MMC: Congress/Gilman Streets Enabling Utility Work

Mike Tremblay <mtremblay@portlandmaine.gov>
To: Helen Donaldson <hcd@portlandmaine.gov>
Cc: Thomas Errico <thomas.errico@tylin.com>

Fri, Apr 19, 2019 at 2:56 PM

12/17/2018
C11-01

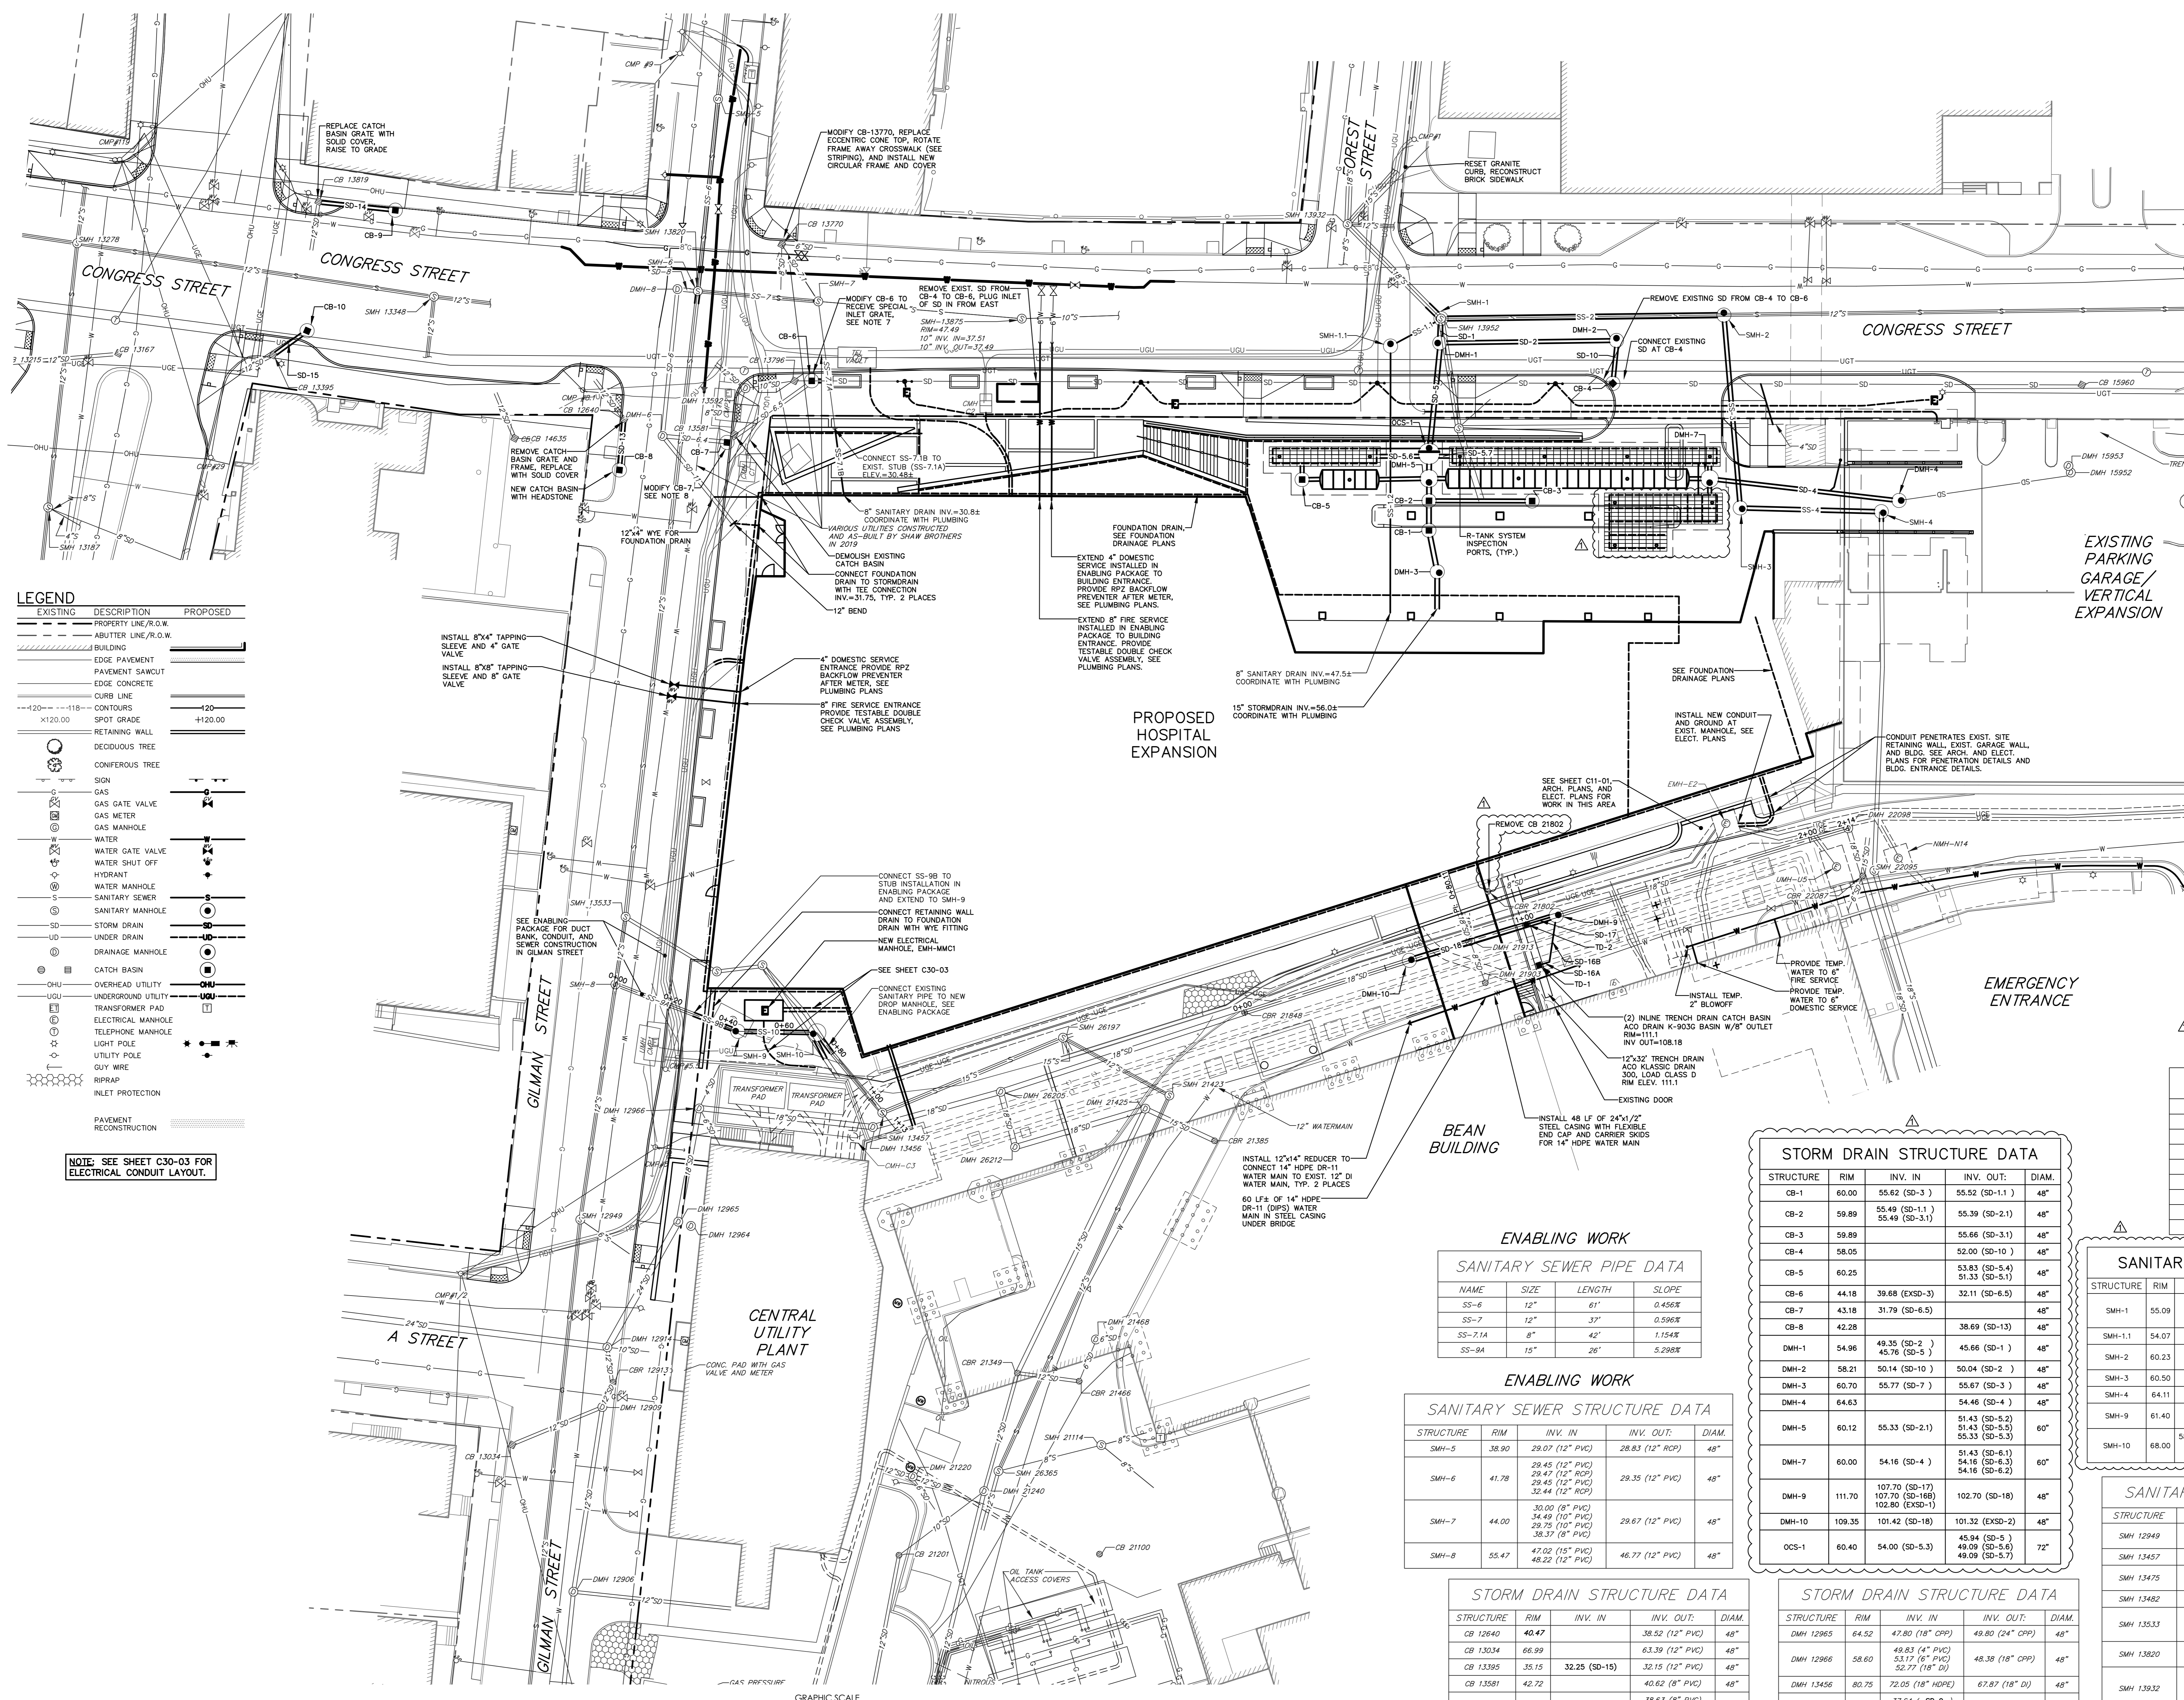
- Manholes and other structures located within the street should be placed as close to the centerline as possible, or aligned with the center of a vehicle travel lane, where at all possible. To the extent practical, proposed manholes should be shifted to align with these goals, possibly including, but not limited to, DMH-1, DMH-2, SMH-7, and SMH-8, all of which appear to be within the wheel path of a vehicle. Note that bicycle lanes should be kept clear of manholes where at all possible. DPW does not expect the applicant to make significant changes to the utility plan to accommodate this request; however, any minor adjustments that can be made will be advantageous to roadway conditions.
